Appeal Decision

Decision date: 09 August 2023

Appeal Ref: APP/R5510/D/23/3321601

46 Willow Grove, Ruislip HA4 6DF

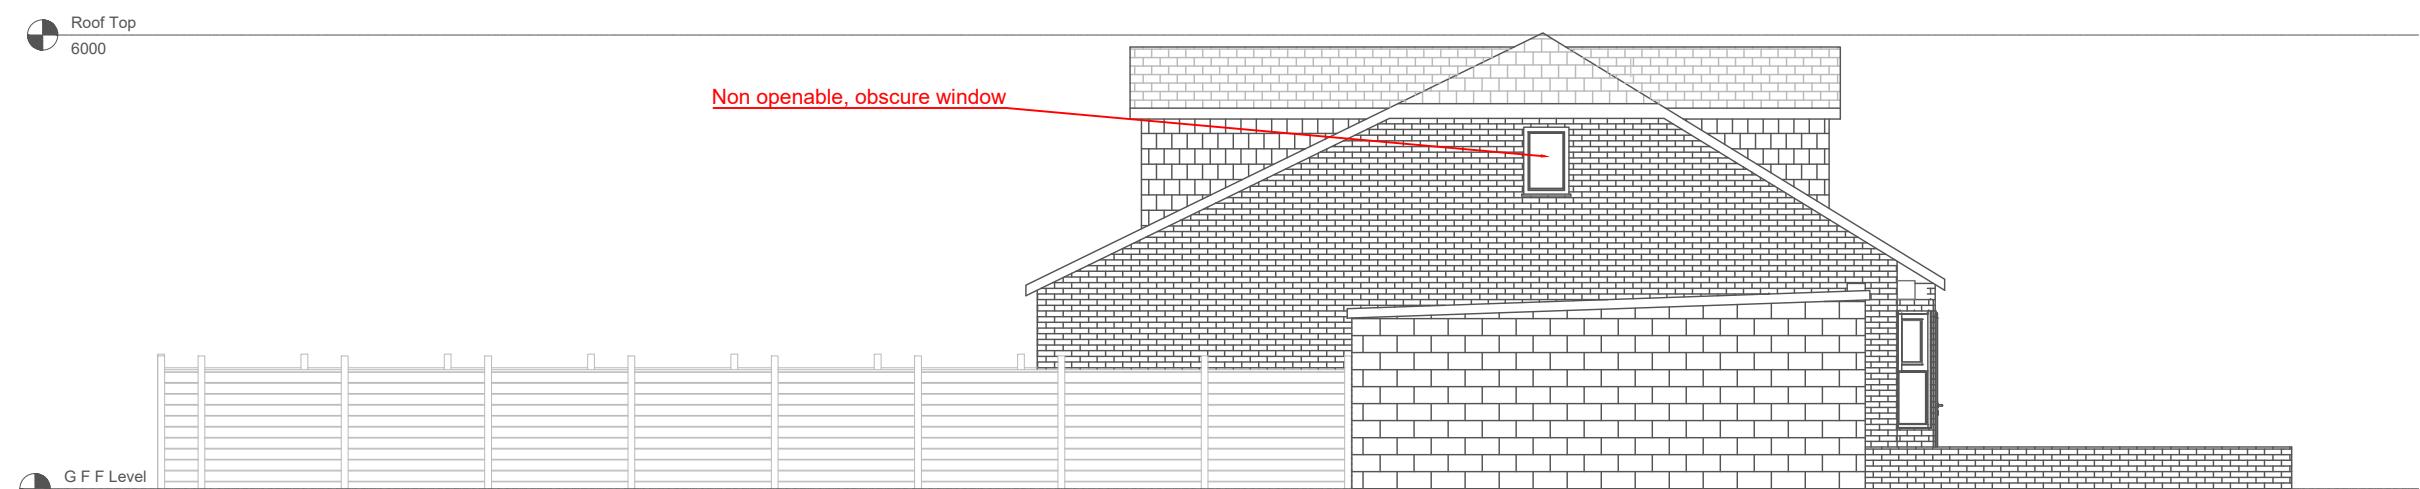
7. The proposed raising of the roof ridge would be out of step with and disrupt the current pattern of development along the street. It would become visually over prominent in relation to the neighbouring properties and within the street scene. The adverse effect on the street scene would be exacerbated with the introduction of the two large dormers on the front roof slope. The combined effect would result in the property, as proposed to be extended, becoming very bulky at roof level and overly dominant in the street scene. The proposal would be visually incongruous with the predominant pattern of development and materially harm the street scene.
